ADC PARKS & GREENSPACE ARBORICULTURE

PLANNING APPLICATION: Y/93/14/OUT

ADDRESS: Land North of Yapton C of E Primary School North End Road
Yapton BN18 0DU

BRIEF DESCRIPTION: Outline Application with some matters reserved for the erection of 40No. dwellings each with a garage(s) and/or parking space(s), together with the means of access off North End Road.

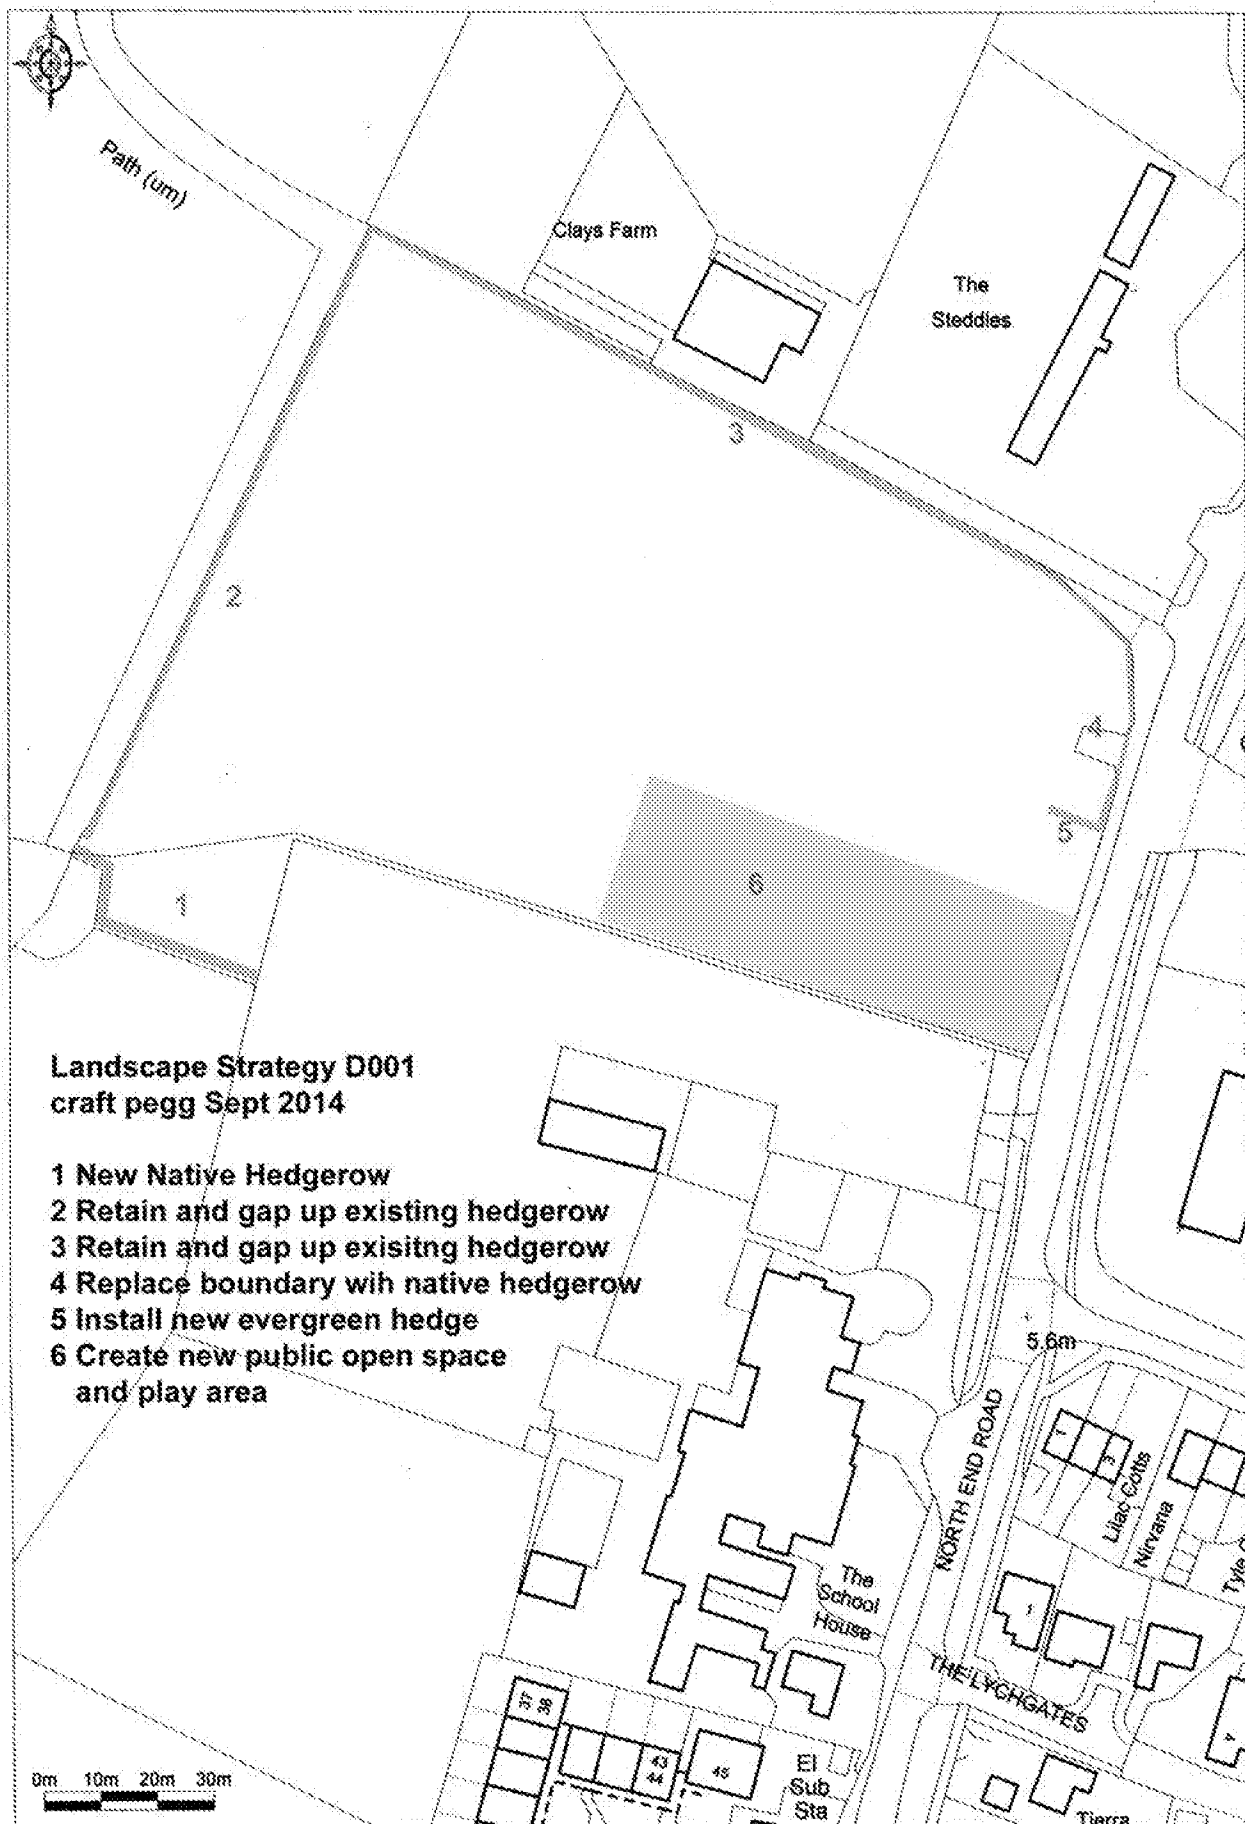
- The applicant has failed to adhere to the BS 5837:2012. This does mean the applicant has failed to;
 1. Produce a Tree Survey & Constraints Plan
 2. Produce an Tree Retentions and Removals Plan

3. Produce a Tree Protection Plan
- The applicant therefore needs to outline the protection/mitigation that would be used for the mainly field maple *Acer campestre* mix hedge line spanning the southern boundary of the site. This protection/mitigation needs to be extended to the few trees located along the western and northern boundary.

SYCAMORE TREE
TO BE REMOVED

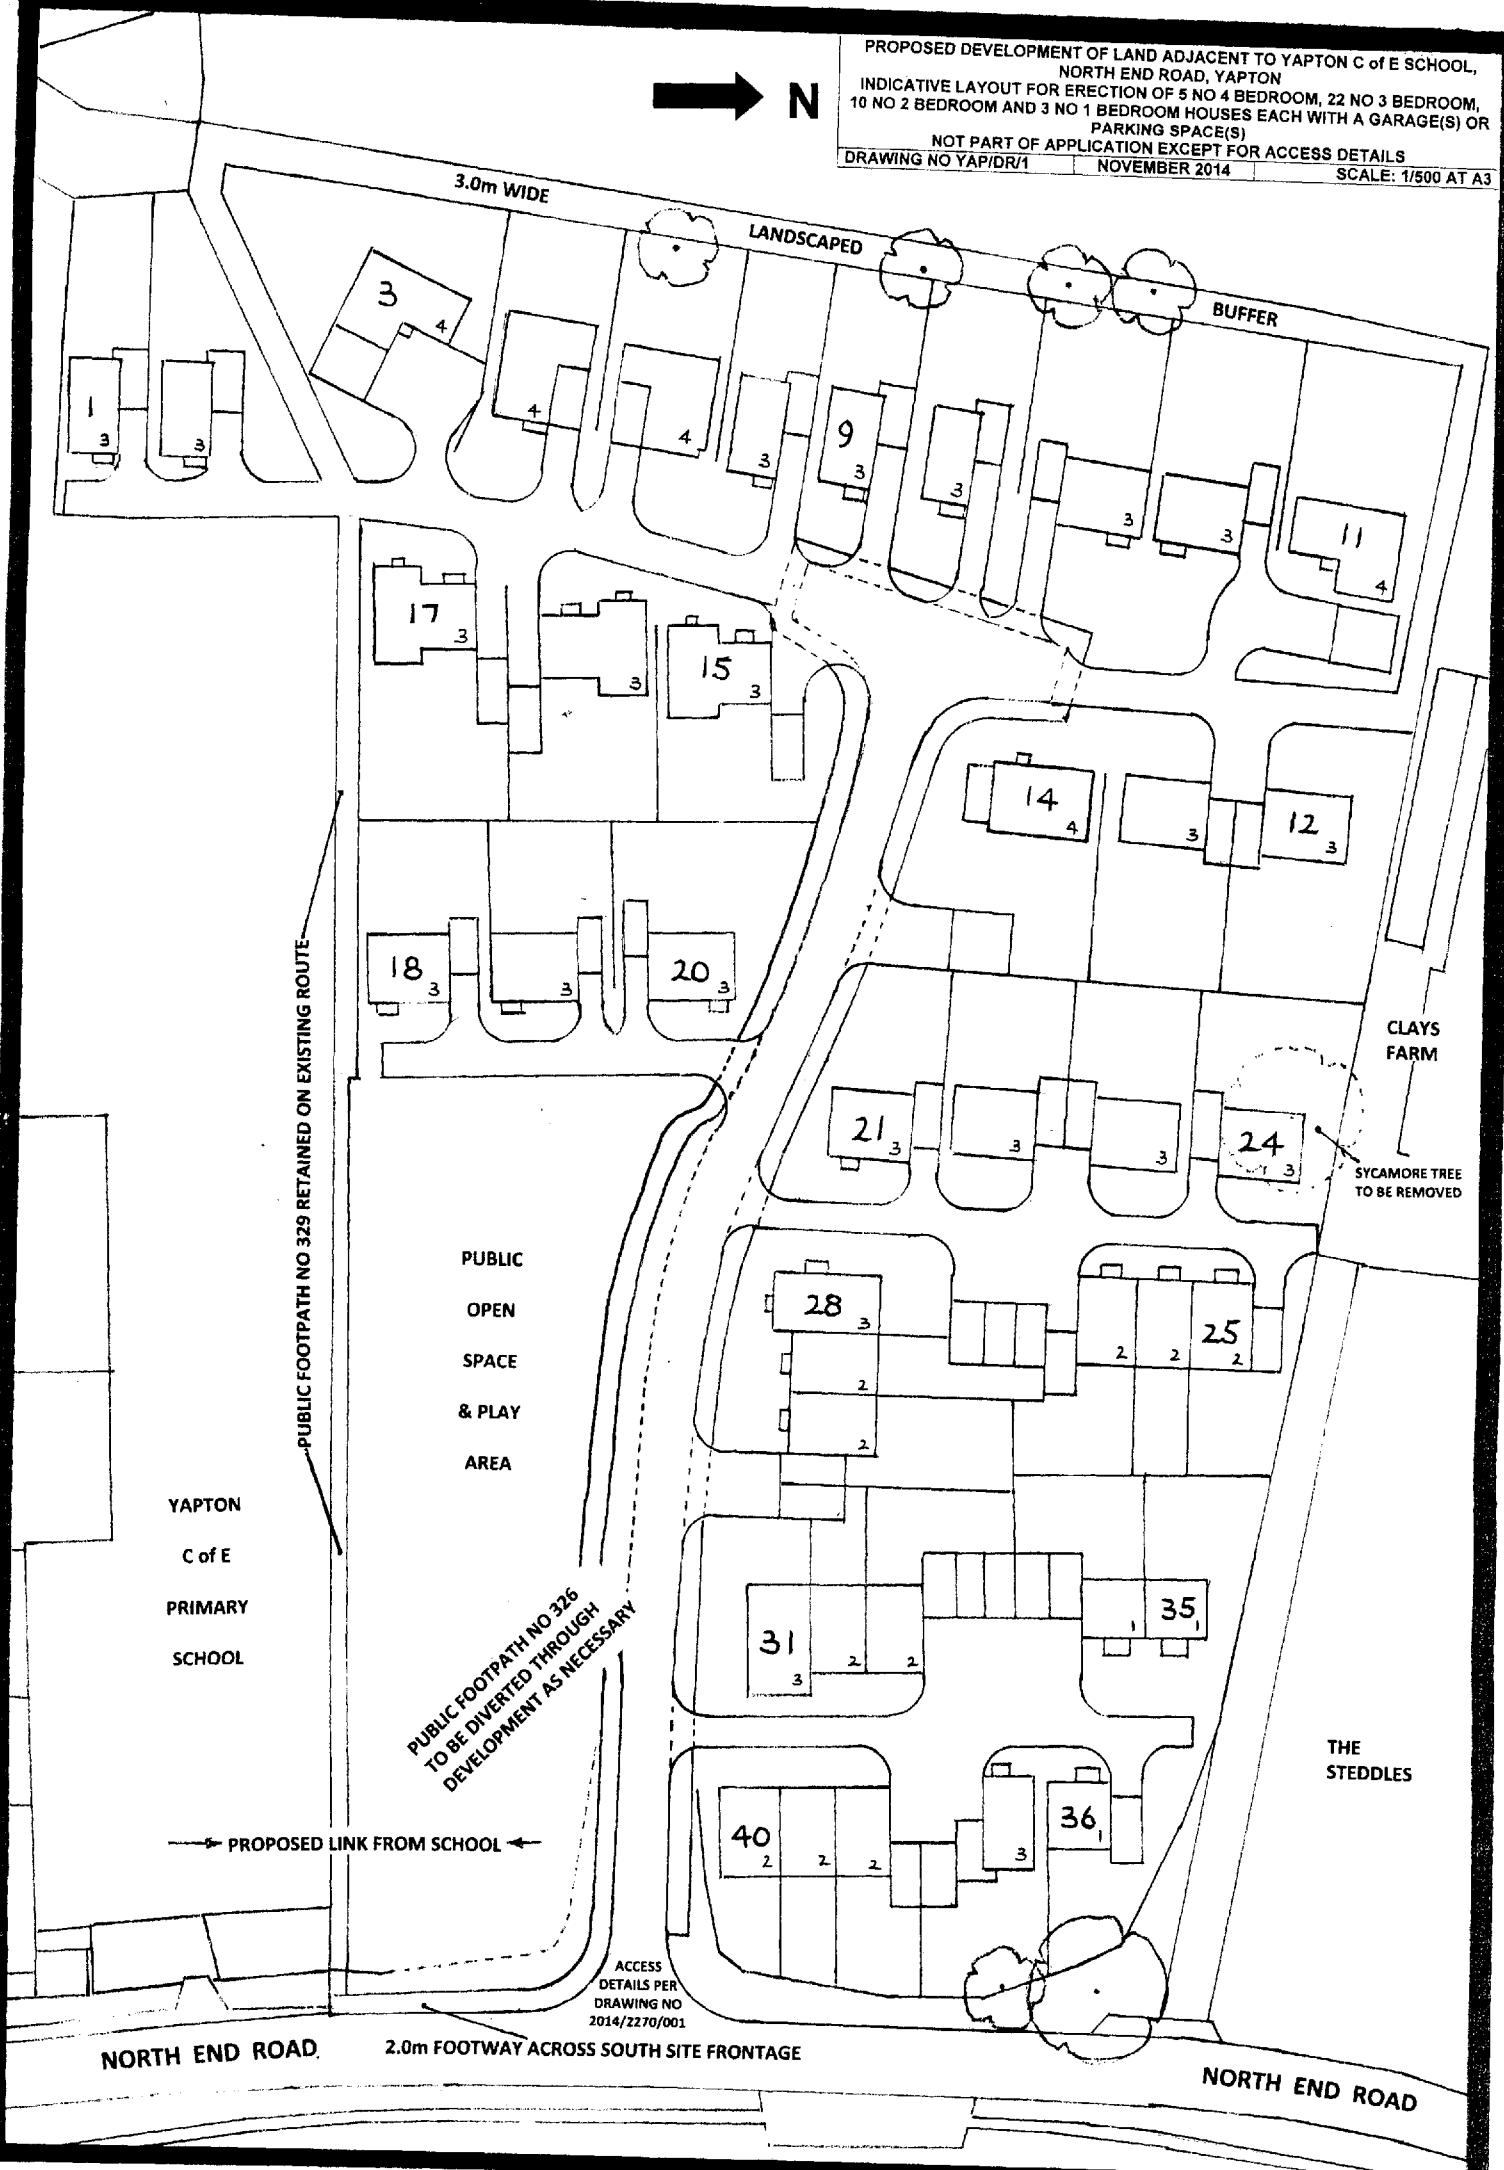
- As for the sycamore tree situated in the northern section of the site. This tree scored 13 on the TEMPO form and is therefore suitable for TPO protection.
